CHENNAI METROPOLITAN DEVELOPMENT AUTHORITY
Thalamuthu Natarajan Building, No.1, Gandhi Irwin Road, Egmore,
Chennai - 600 008

(Development Charges Letter)

File No. : CMDA/PP/NHRB/S/1092/2019

Sub: CMDA-Area plans Unit - 'B' Channel (South) – The Planning Permission Application is for the proposed construction of Stilt floor + 3 floors (12.0 m height) Residential building with 6 dwelling units with availing Premium FSI at Plot No.149, Defence Officer Colony, 12th Cross Street, Nandambakkam, Chennai 600089 in Old S.No.163, Patta S.No.163/39 of Nandambakkam Village within the limit of Greater Chennai Corporation - Remittance of DC & Other charges – DC advice Sent - Reg

SITE CUM STILT FLOOR PLAN

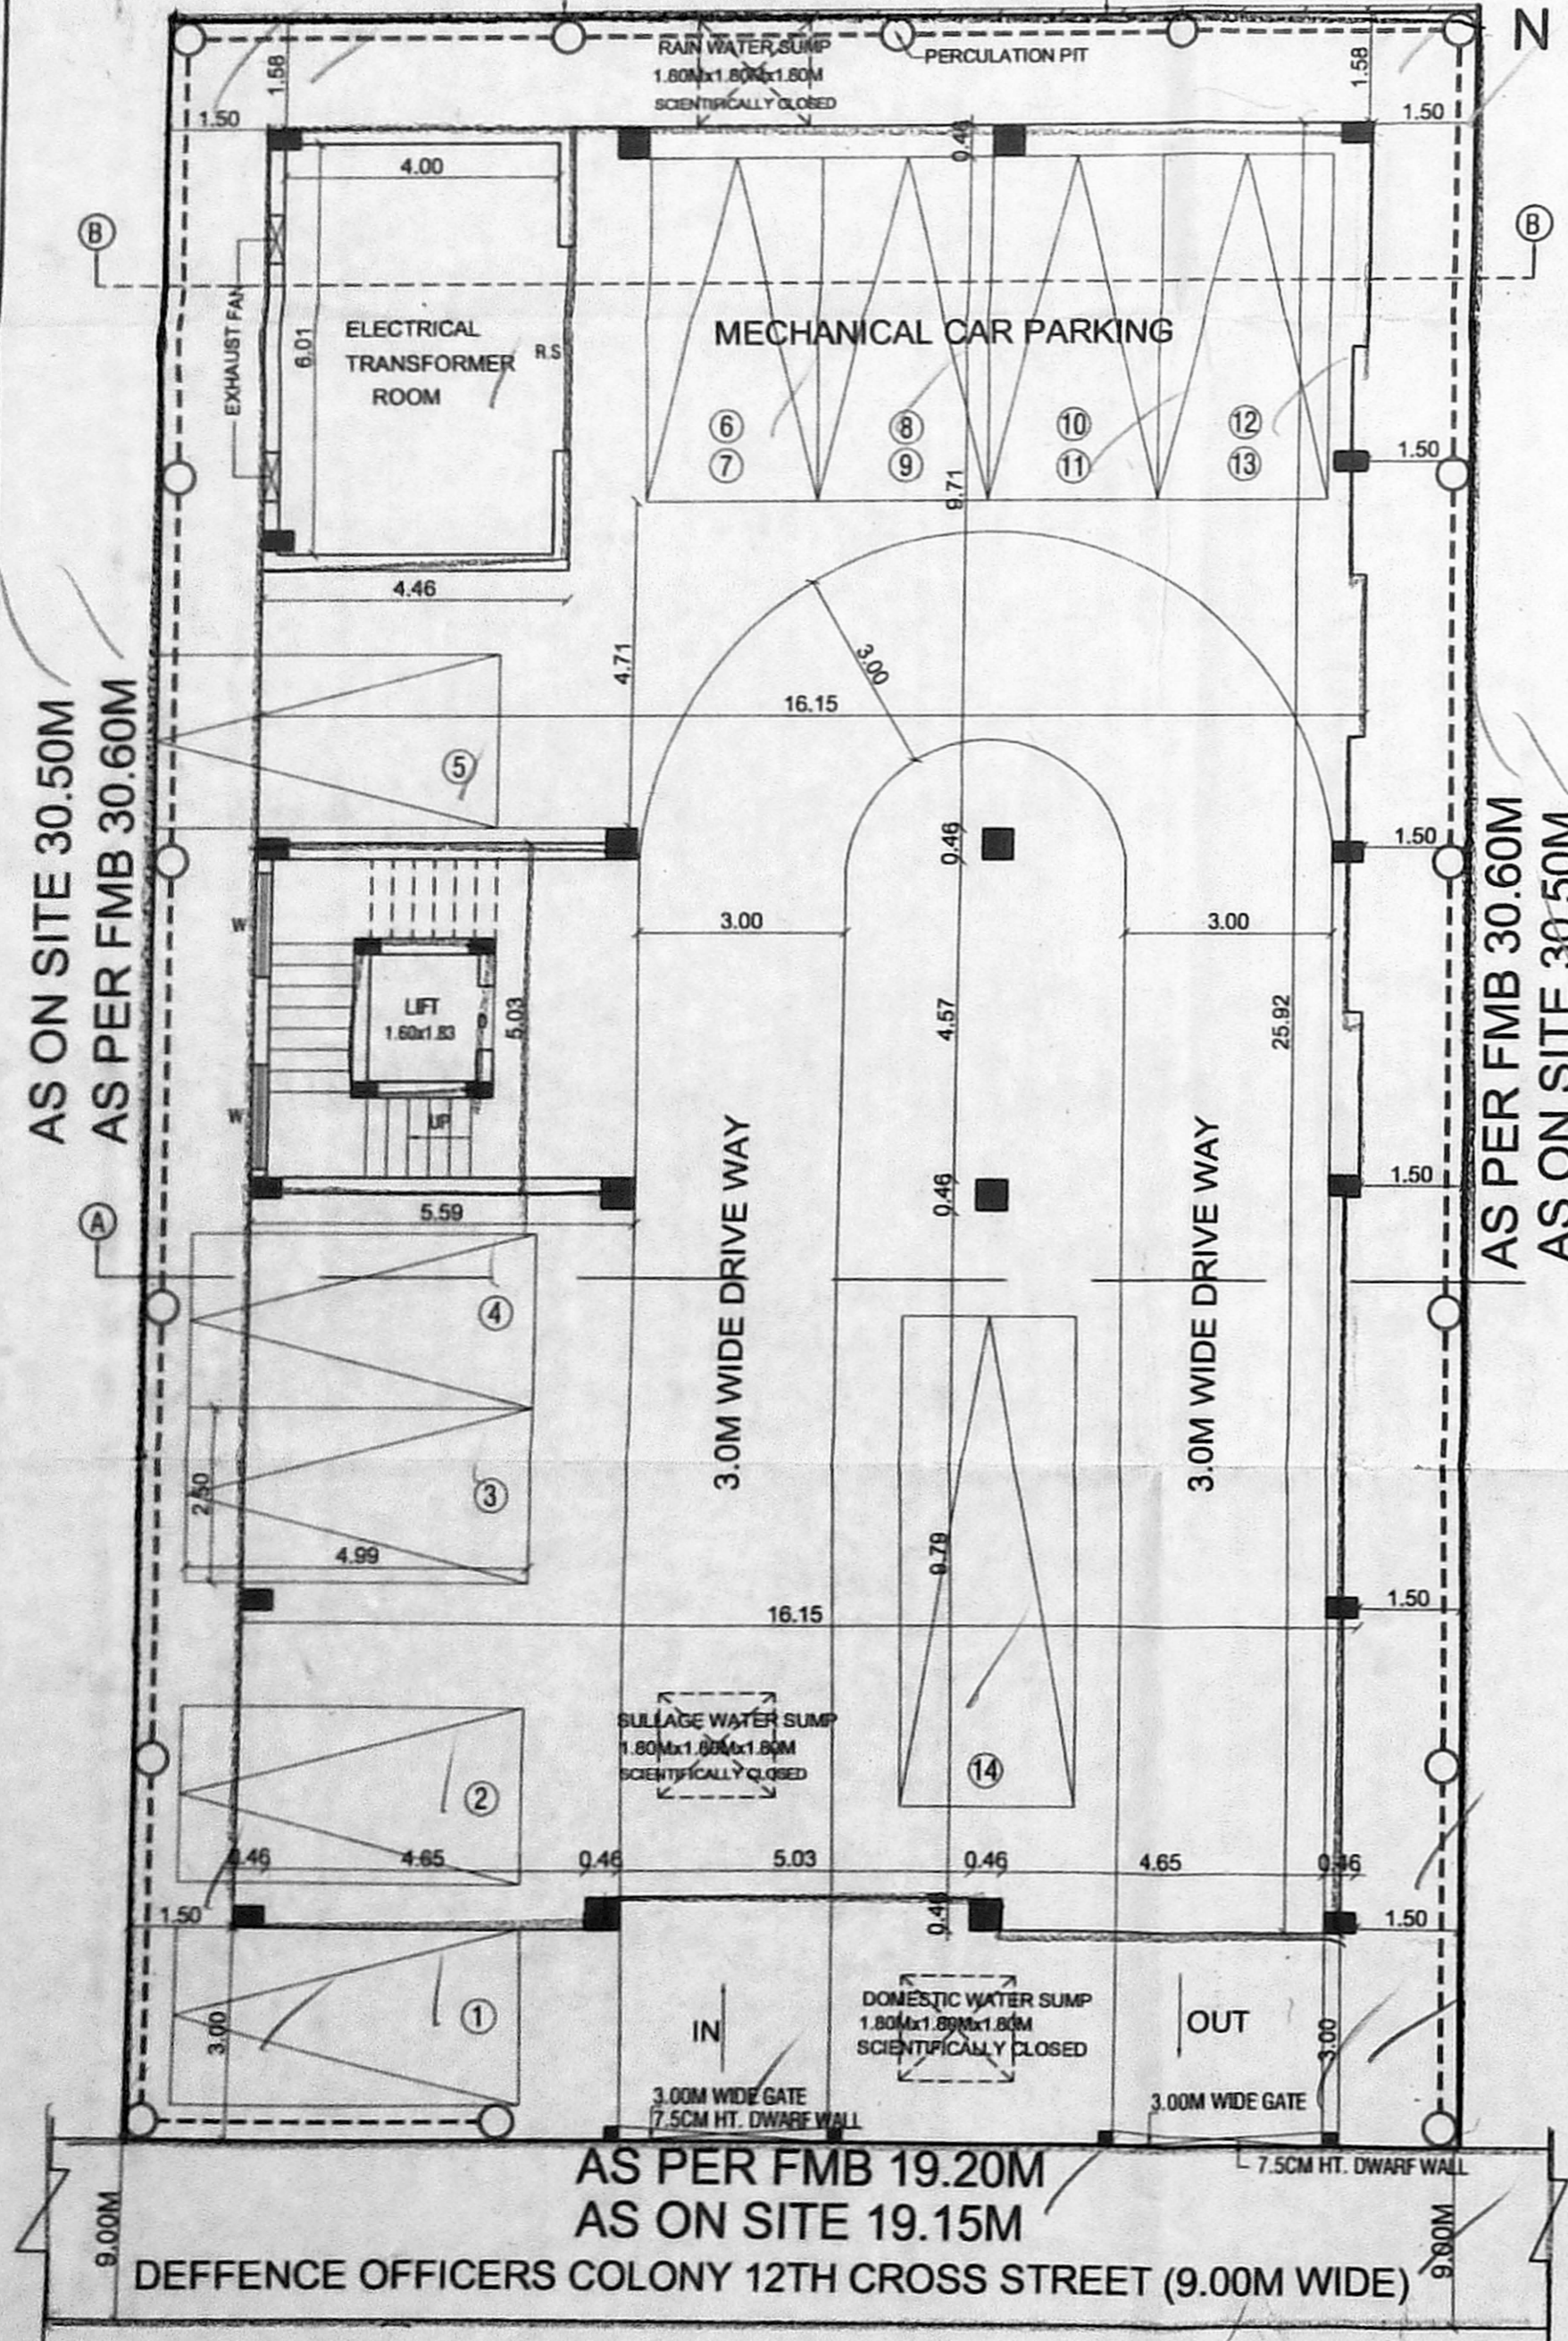
- Parking to be rearranged to accommodate required number of parking.
- Patta in favour of present owner to be furnished.
- FMB sketch attested by Revenue officials not below the rank of Deputy Tahsildar to be furnished.
- As on site Dimension, building size and setbacks to be corrected as per inspection observation.
- In and out gate to be shown in the site plan.
- Area statement needs correction.
- Electrical-room to be renamed as Electrical Transformer Room
